11 December 2024

**Ref No:** F2024/00464

**RE: SSD 71454960 - Redevelopment at 195-213 Fitzgerald Avenue and 40-64 Yorktown Parade, Maroubra by Homes NSW**

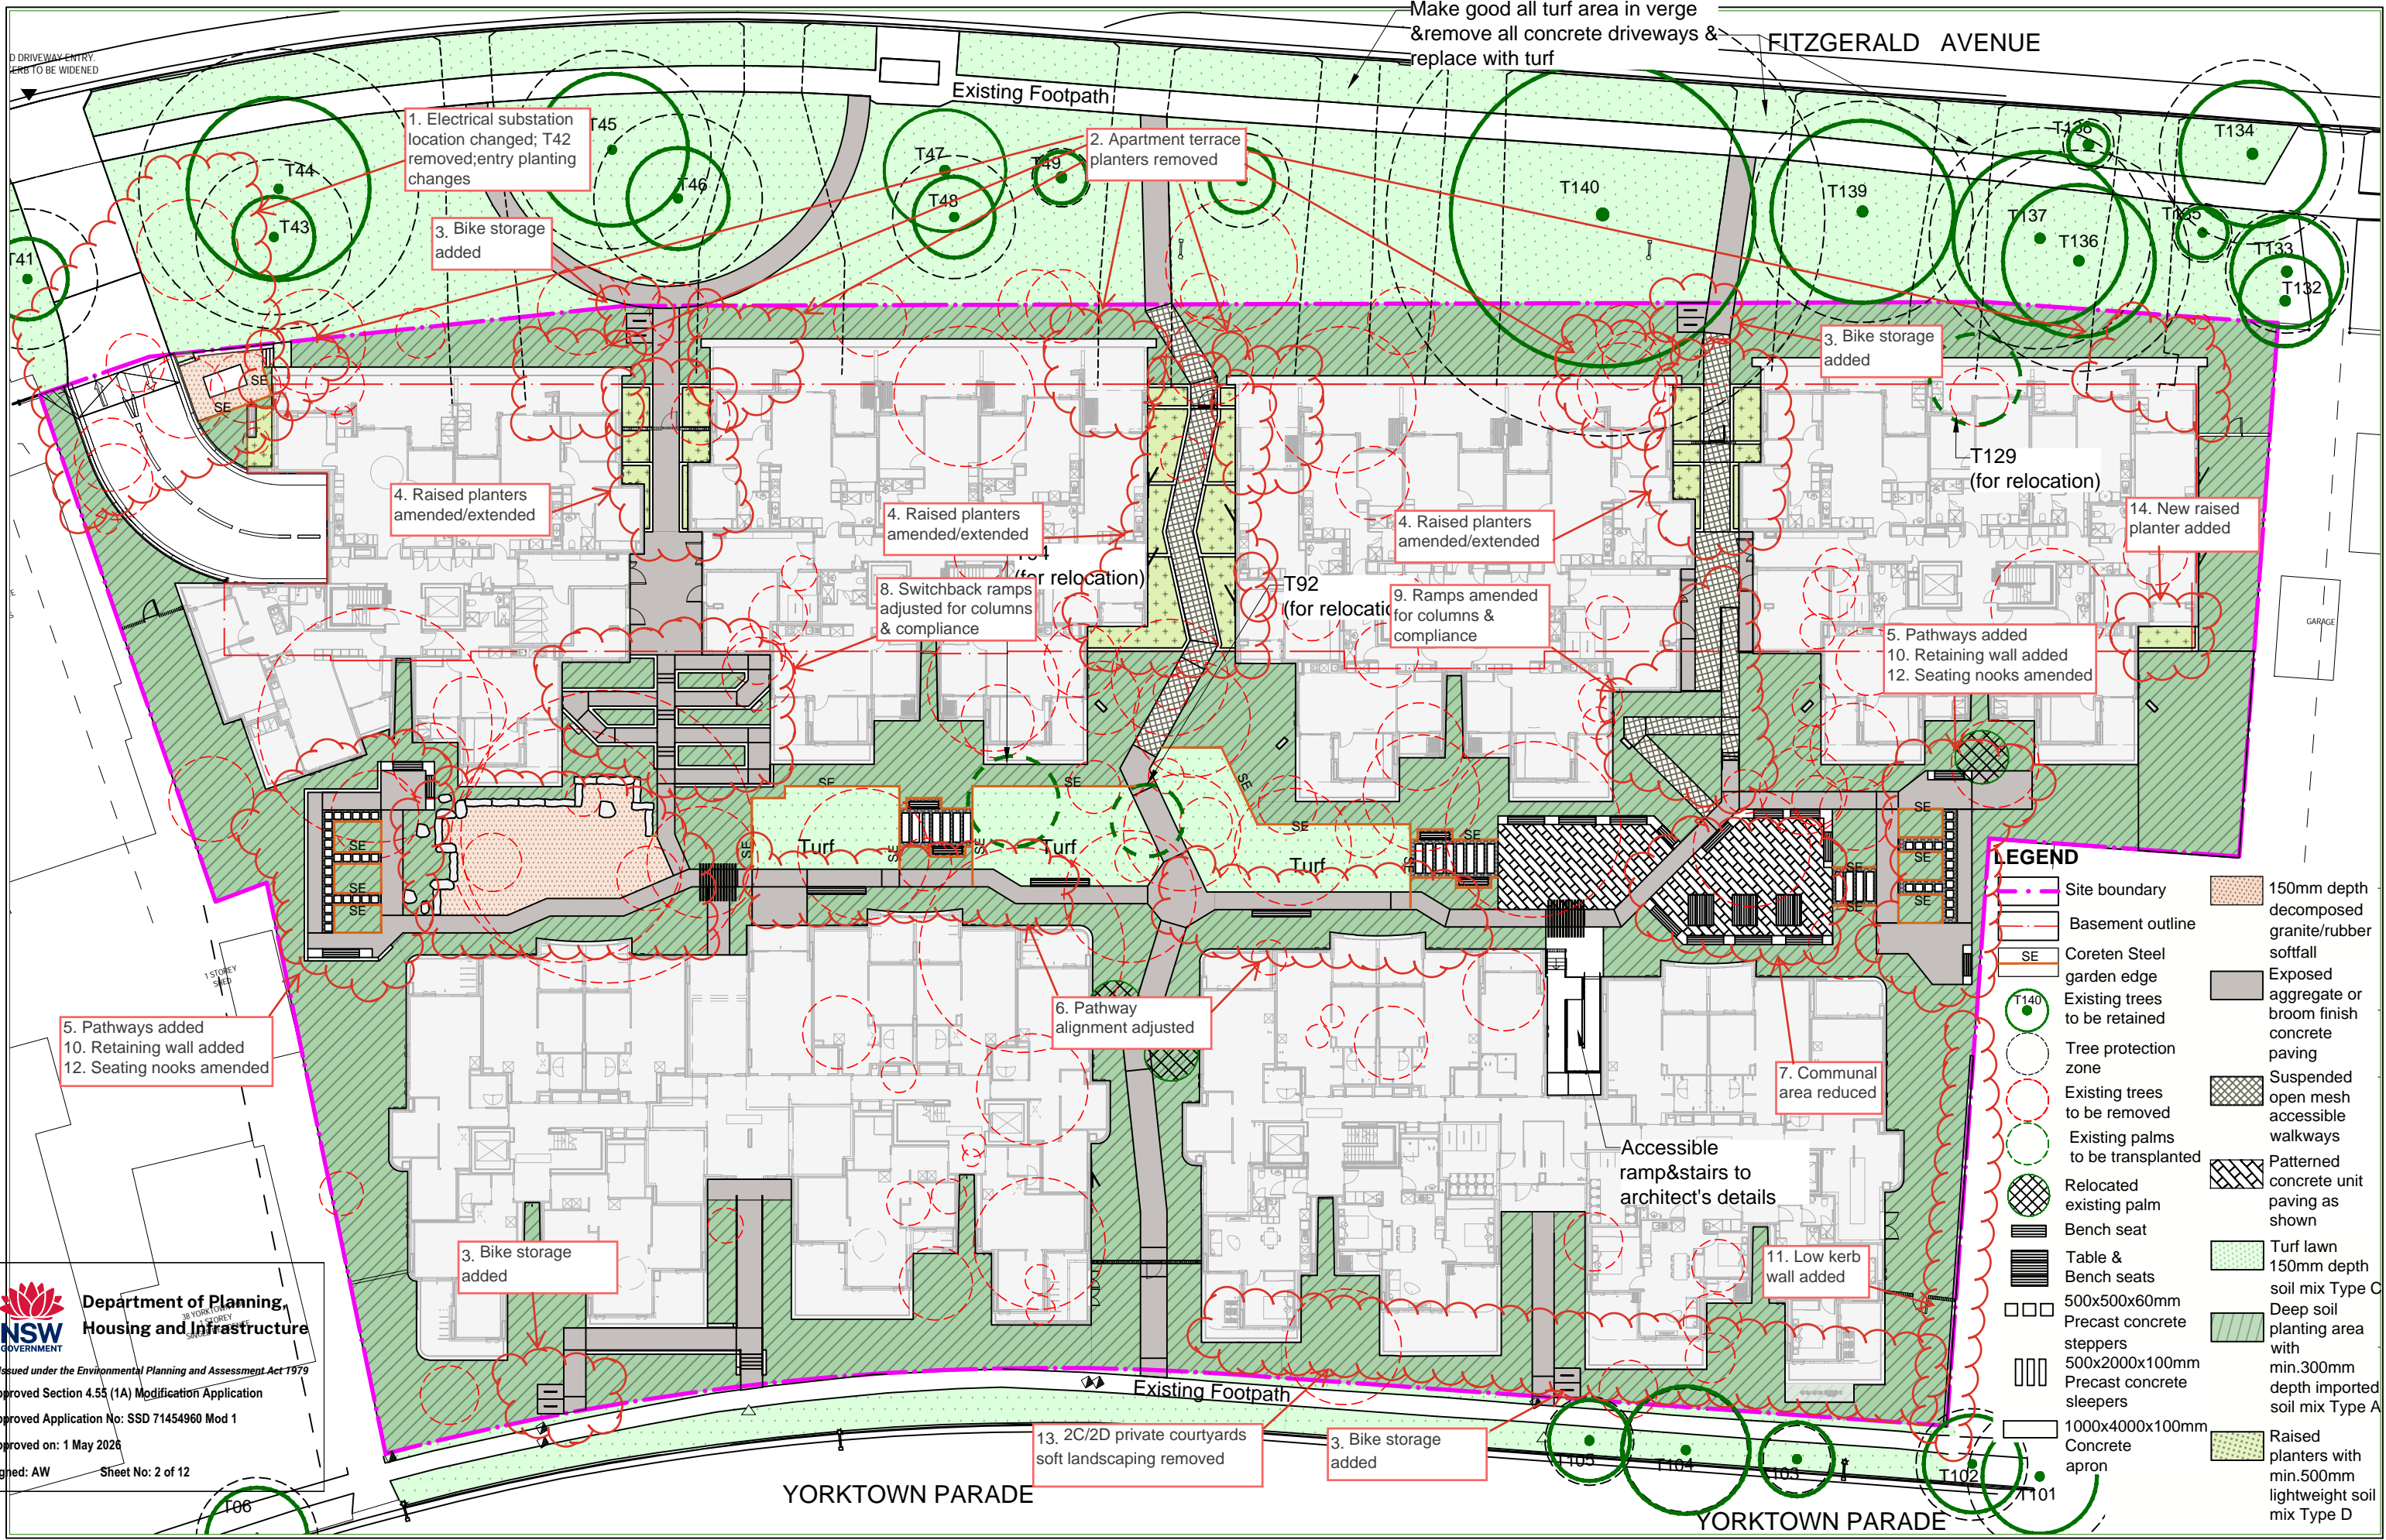
In this regard, particular attention is drawn to potential impacts arising from the new vehicle crossing adjacent T41-44, the new external footpath adjacent T140 (which will need to be provided above existing grades to avoid the huge buttress roots at surface level throughout this area) as well as the new external stormwater pipe in Yorktown Parade adjacent T2.

It is critical that species selection for any new street trees in Fitzgerald Avenue does not result in over-crowding of the Figs and should be 'infill plantings' only, with any new street trees in Yorktown Parade to be mindful of restrictions created by the overhead power lines along this frontage. New tree planting locations must also consider the need for passive surveillance around external footpaths, site entries/exits and similar.

EXISTING CANOPY WITHIN SITE BOUNDARY TO BE RETAINED

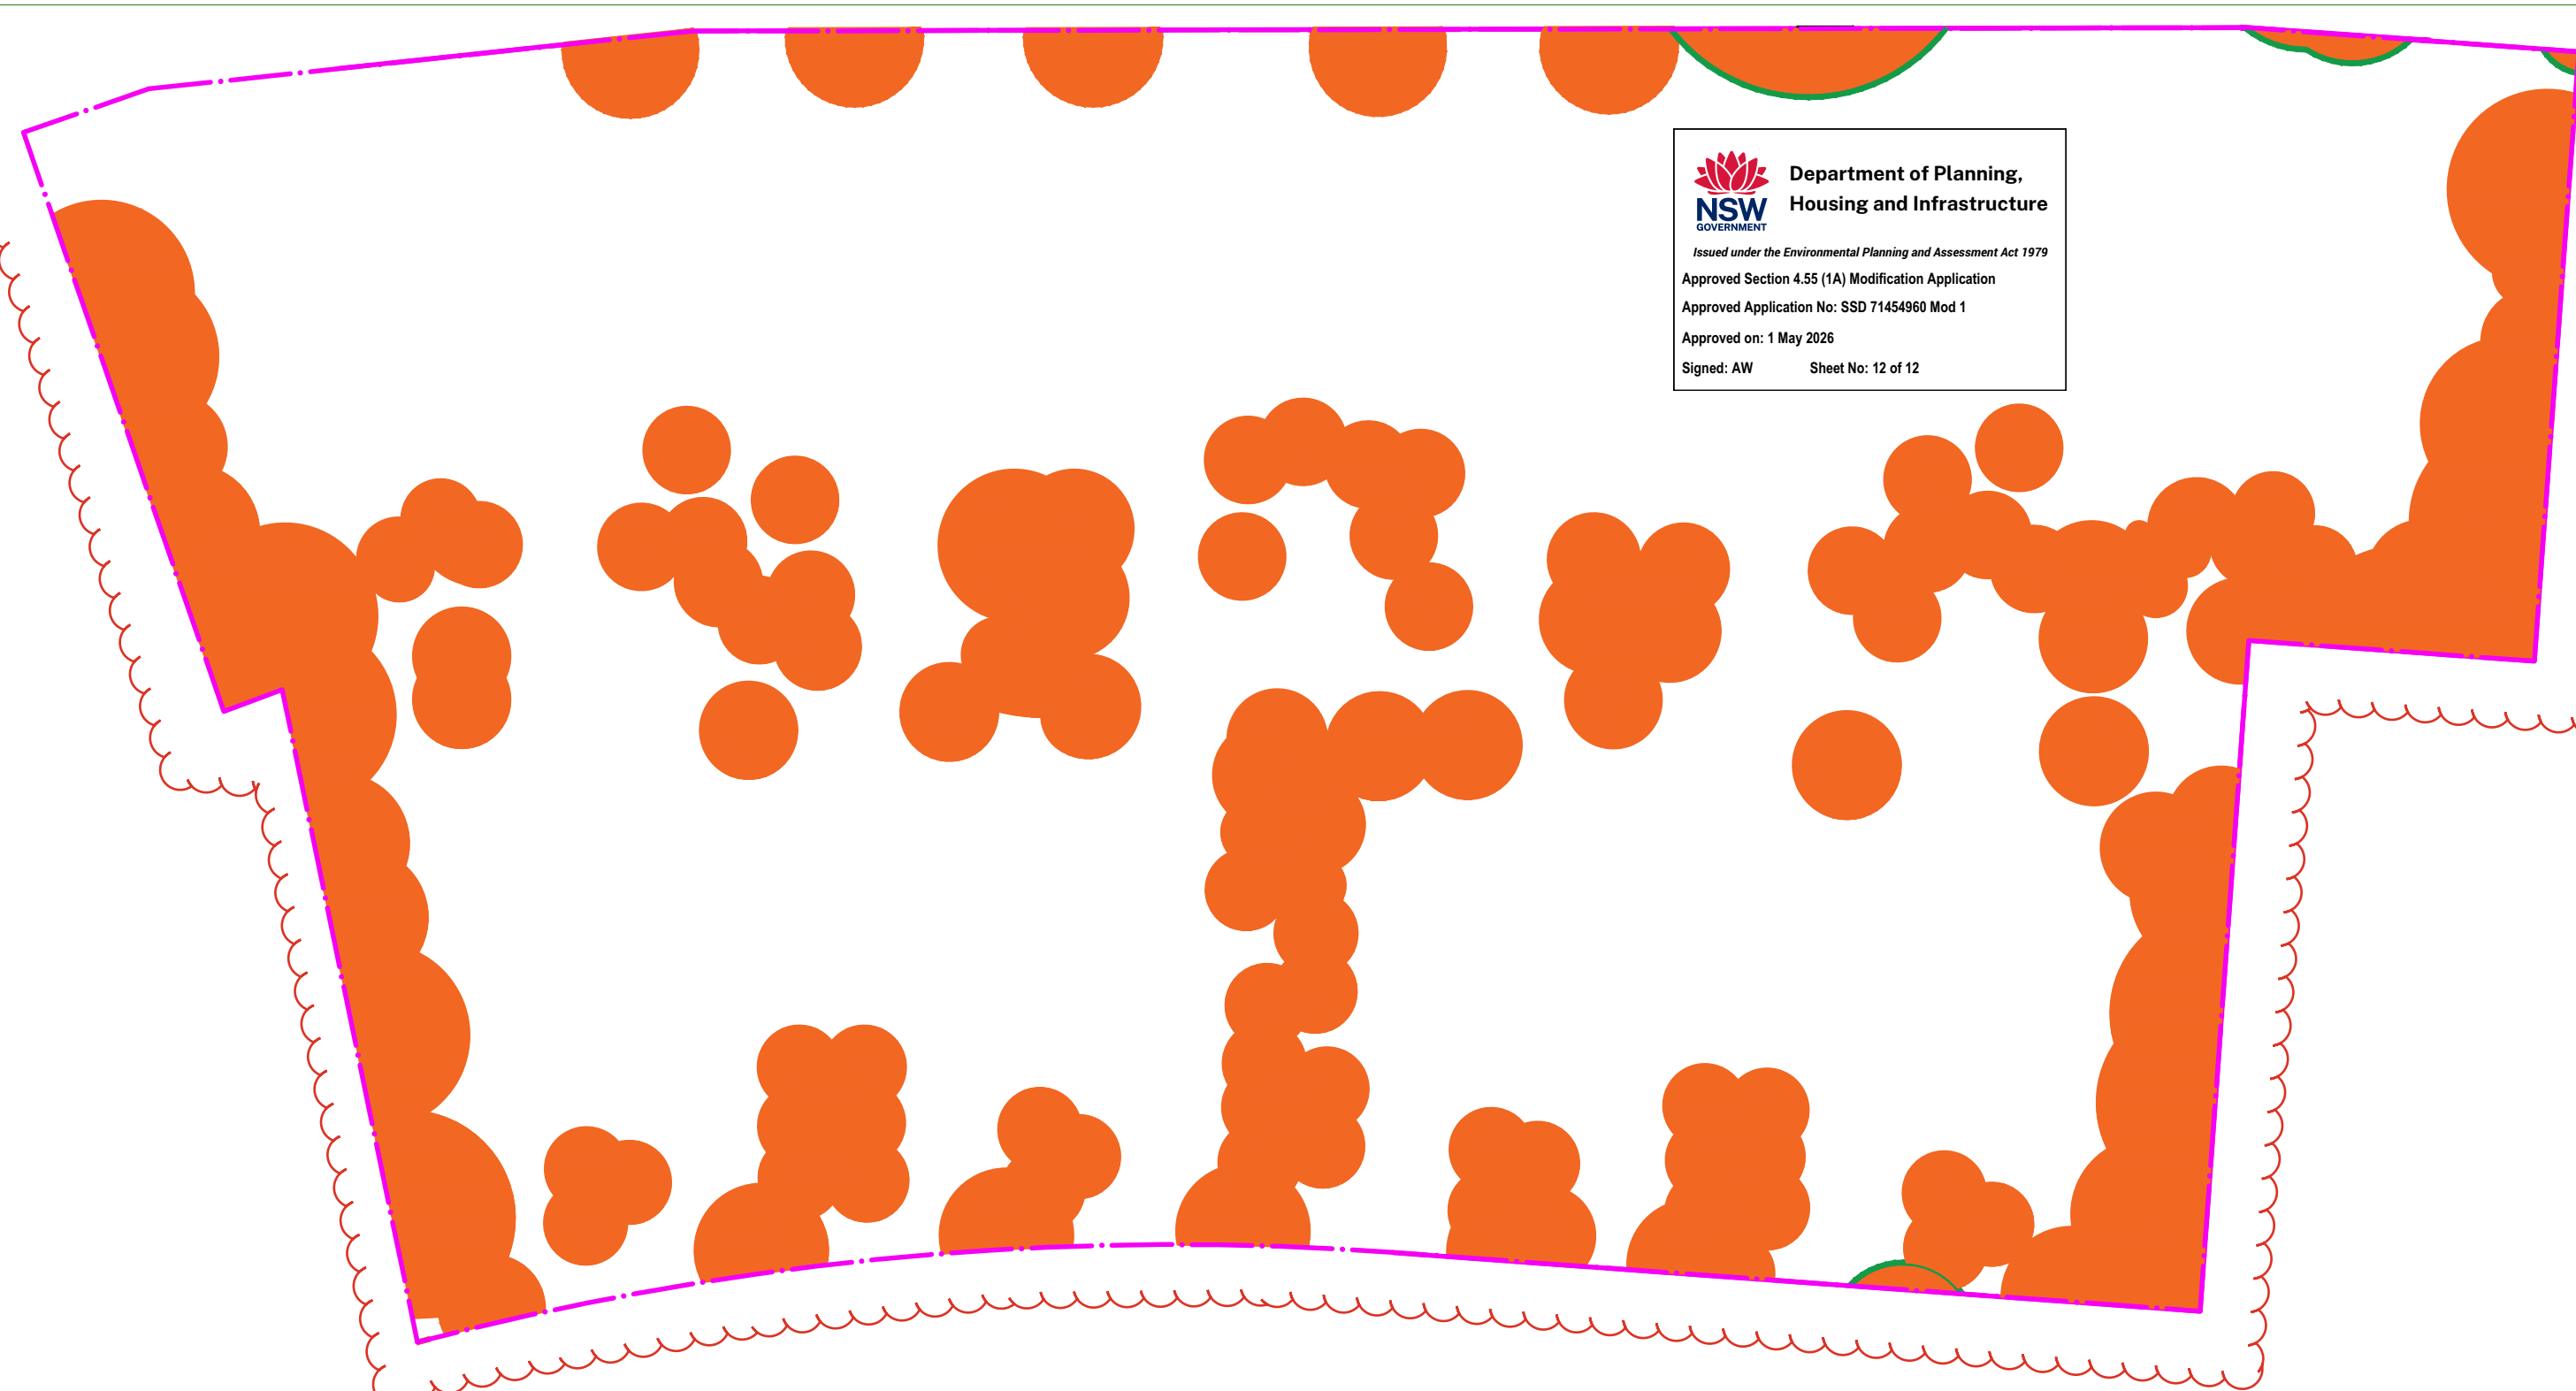
Council is supportive of the high level of street tree retention on both Fitzgerald Avenue and Yorktown Parade and along with the substantial deep soil and landscaping areas proposed. Regarding canopy cover, as shown in the application documentation, the proposal at 24% does fall short of the 30% target contained within the DPHI greener places guidance.

Given substantial reduction in vehicle crossovers to Fitzgerald Avenue and Yorktown Parade and the associated increase in potential landscape / planting area, it is recommended that new street tree planting be incorporated into the proposal to assist with offsetting any reduced canopy cover that can be achieved within the subject site.

As several large tree species are located within the Fitzgerald Avenue verge, appropriate space should be retained for these species to reach maturity. It is therefore recommended that any proposed street tree planting be directed to Yorktown Parade.
